Submission on SSD-89869959 – Technical Compliance and Document-Integrity Review

10 Dangar Street, Wickham NSW 2293

To: The assessment officer, NSW Department of Planning, Housing and Infrastructure, in respect of SSD-89869959 (concurrent rezoning and 43-storey mixed-use development, 10 Dangar Street, Wickham).

Level 08-11 co-living

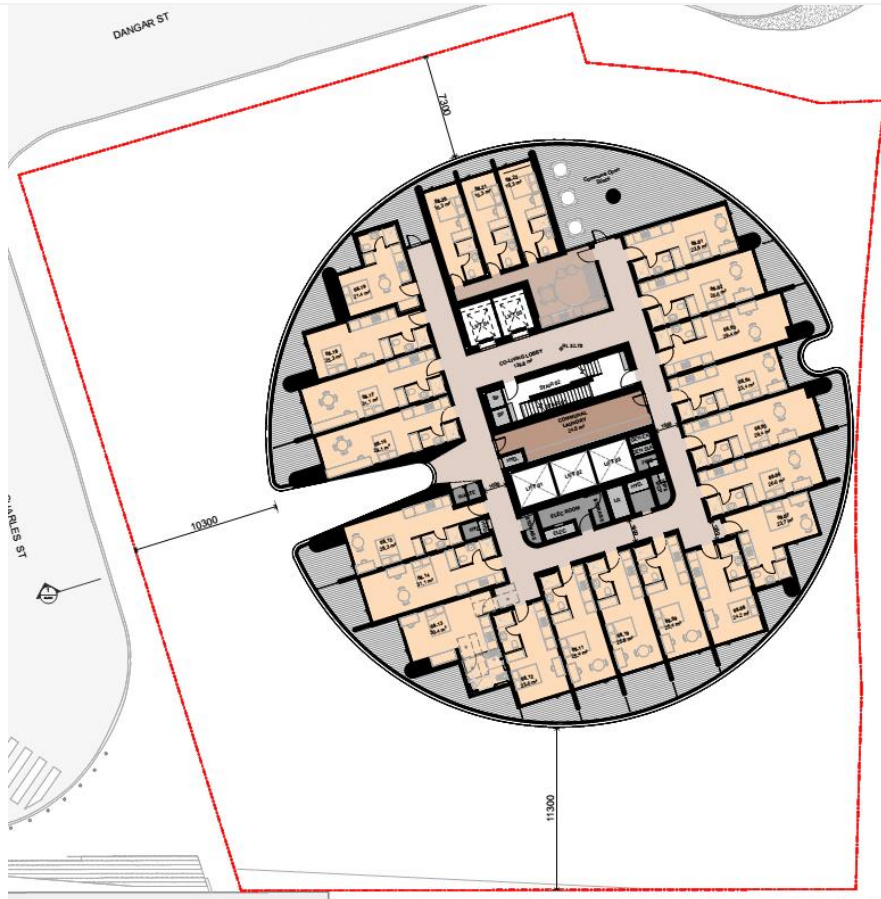
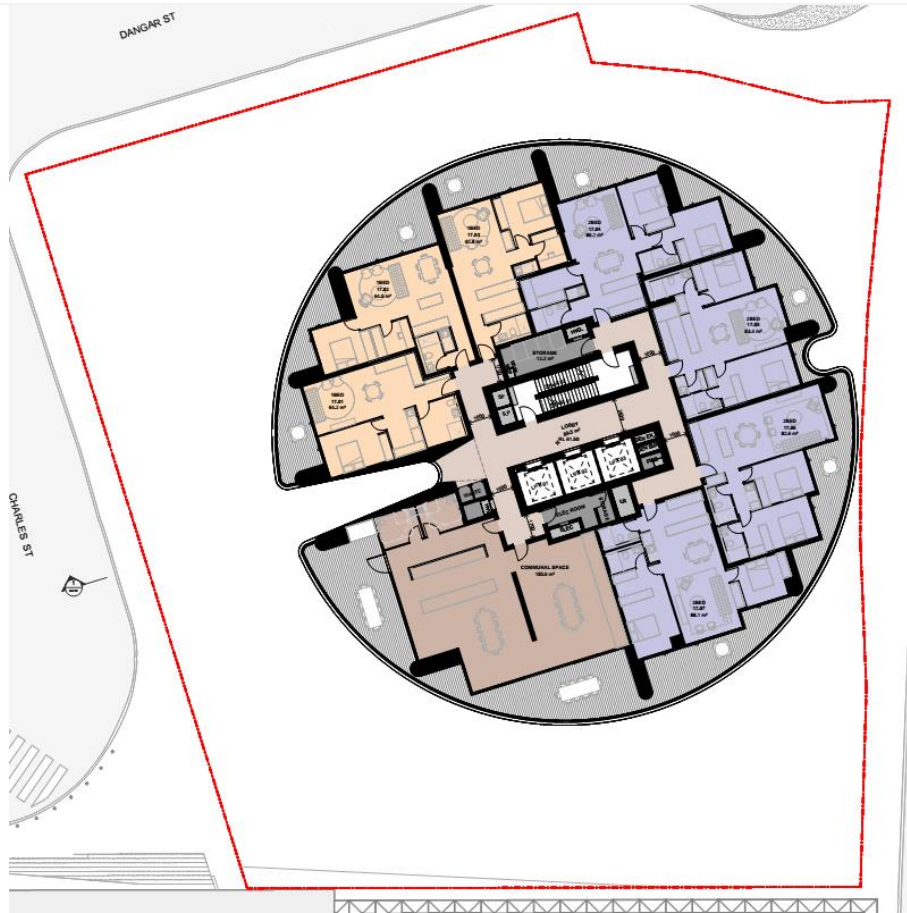
Deficiency: Room sizes, natural light, ventilation and storage for the co-living rooms are not demonstrated against the applicable minimums in the exhibited material; the SDRP recorded co-living amenity as unresolved at its second review.

Resolution sought: A co-living room amenity schedule.

# Level 6 Residential Communal Open Space

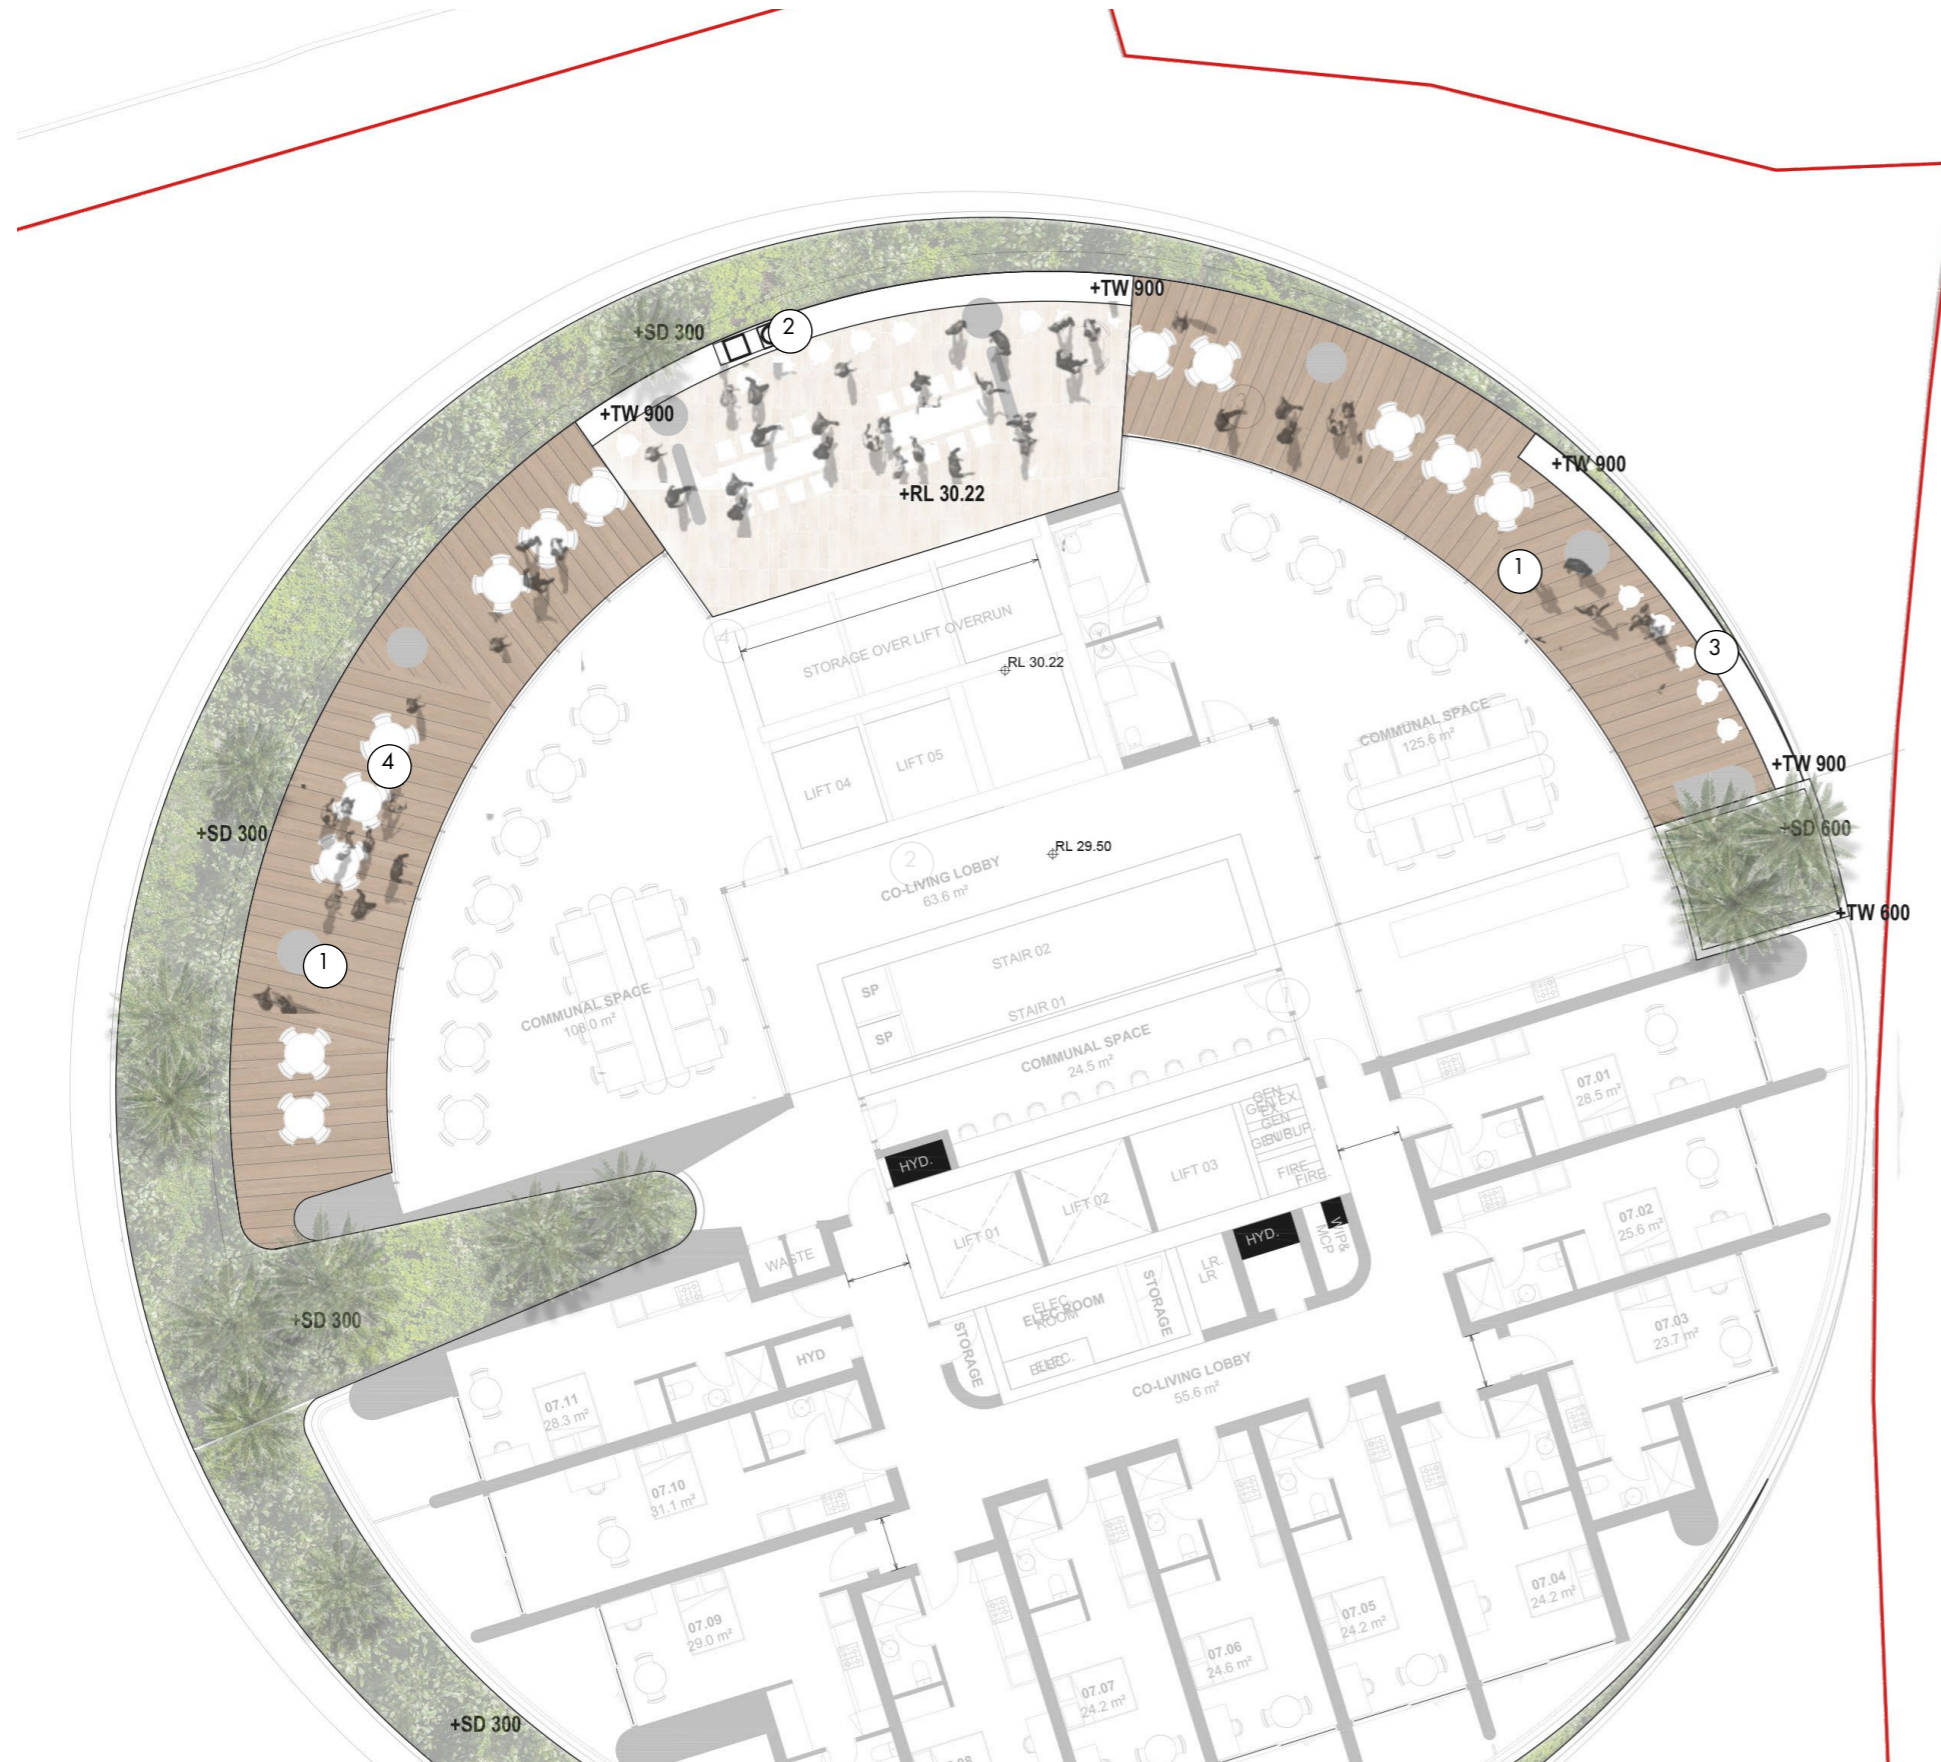
Exhibited position: Residential external communal open space recorded at 745 m² (just over 25%), plus 150 m² internal; co-living 627 m² external plus 229 m² internal. The 50%/2-hour solar outcome for the principal usable area is **not demonstrated**.

Deficiency: Area compliance is asserted but the qualitative solar criterion — the part that determines whether the space is usable in winter — is not shown. The Level 6/7 communal areas are described as view-oriented and landscaped without a solar overlay.

Resolution sought: A solar diagram for each communal open space identifying the principal usable area and the proportion receiving 2 hours mid-winter sun.
